Engineers Comments Regarding Surface Water Drainage

Application Reference:	LU/72/25/OUT (2)	Reviewer Reference:	ADC/EXT5/AF
Planning Officer:	Emma Sheppard	Date of Review:	22/01/2026
Site Name:	Land to the West of New Courtwick Lane Wick BN17 7RZ		
Application Description:	Hybrid Planning Application comprising of the following: 1) - Outline application with all matters reserved (except access) for Phase 2 (West of Site) comprising development of approximately 8,800sqm GIA Light Industrial/Storage and Distribution (Use Class E(g)(iii) / B8), and 2) - Full Application for Phase 1 (East of the Site) for a food store (Use Class E(a)), 2 No. Drive-Thru food/beverage units (Sui Generis) with revised vehicular access, associated parking and landscaping. This application may affect the setting of a listed building and is in CIL Zone 2 and is CIL Liable.		
Assessment Number:	5

Application Reference:	LU/72/25/OUT (1)	Reviewer Reference:	ADC/EXT5/AF
Planning Officer:	Emma Sheppard	Date of Review:	22/01/2026
Site Name:	Land to the West of New Courtwick Lane Wick BN17 7RZ		
Application Description:	Hybrid Planning Application comprising of the following: 1) - Outline application with all mat

2255-P-004A

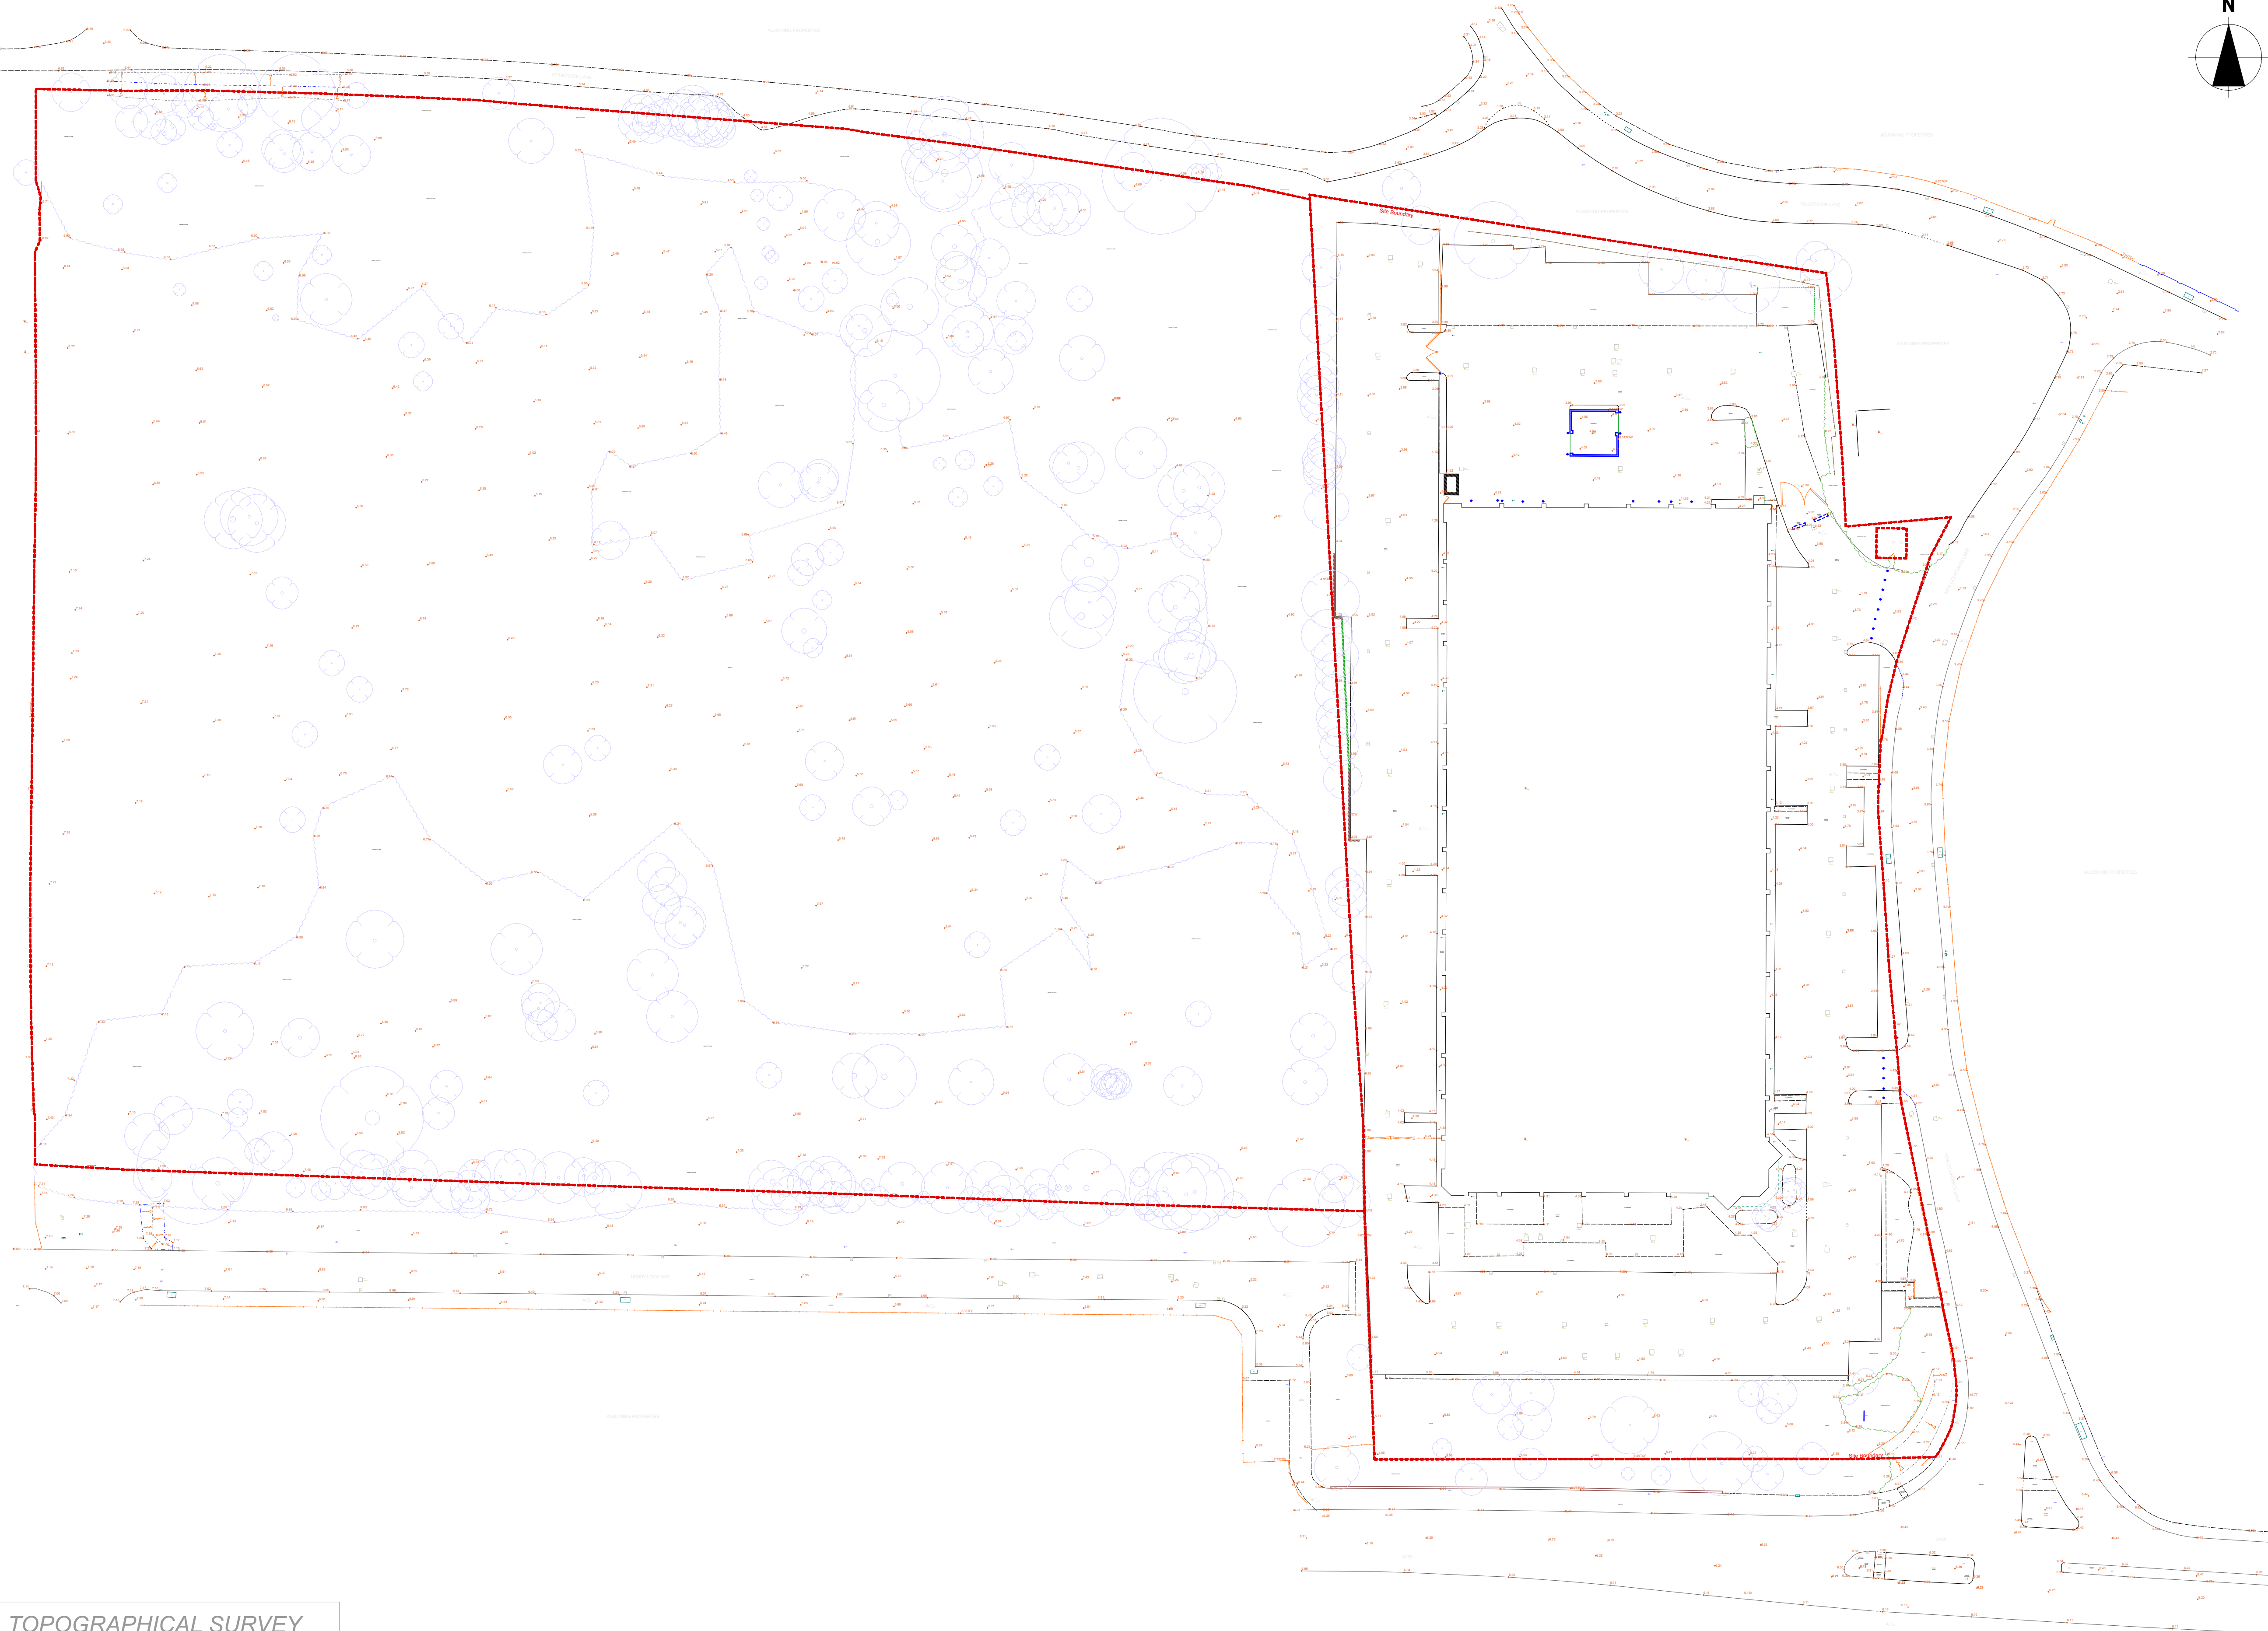
- 0.9. The proposed scope of the infiltration testing is limited by the existing building that is not yet demolished. The spread of testing is sufficient to overcome an objection to the principle of infiltration viability (for this full application). However, it is not sufficient for detailed design purposes.

- 0.10. Should the principle of infiltration be adequately demonstrated then further testing, in the areas beneath where the building currently stands, will be necessary. It is important to record the strata in the trial pits. There is a risk that the strata beneath the building could be made ground to a

depth greater than the proposed infiltration blanket which may further restrict the area possible for infiltration.

- 0.11. Careful evaluation of shallow infiltration testing in the area of the existing car park and road is also important as the higher section of the test pit will be made ground formed of the foundation for the existing pavement.
- 0.12. Ground water levels measured in accordance with our published guidance should be compared with the design base of storage relative to Ordnance Datum to confirm compliance with National SuDS Standards requirements.

- 3.2. There is an area of surface water flood risk between the outline and full planning application sites. The proposed cover levels do not appear to be altered significantly from the existing topographical survey. However, the proposed levels will require further scrutiny to ensure that flood risk is not increased by the proposed development.
